**SOUTH DUBLIN COUNTY COUNCIL'S PLANNING AUTHORITY'S REPORT TO
AN BORD PLEANALA ON**

**APPLICATION FOR FURTHER
DEVELOPMENT CONSENT UNDER
SECTION 37L**

**AT BEHAN'S QUARRY
WINDMILL HILL, RATHCOOLE, COUNTY DUBLIN**

**Land Use Planning and Transportation Department
South Dublin County Council
County Hall
Tallaght, Dublin 24
Prepared by: Tracy McGibbon
Date of Report: 18th August 2021**

View 1 - Opposite the existing quarry entrance.

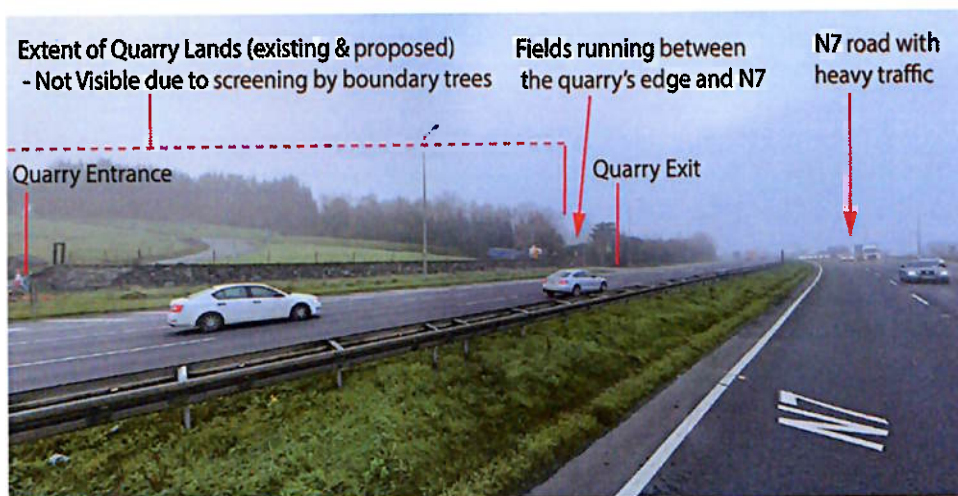
- 5.3.8 Photomontages of the development from the N7 would be beneficial for the assessment.
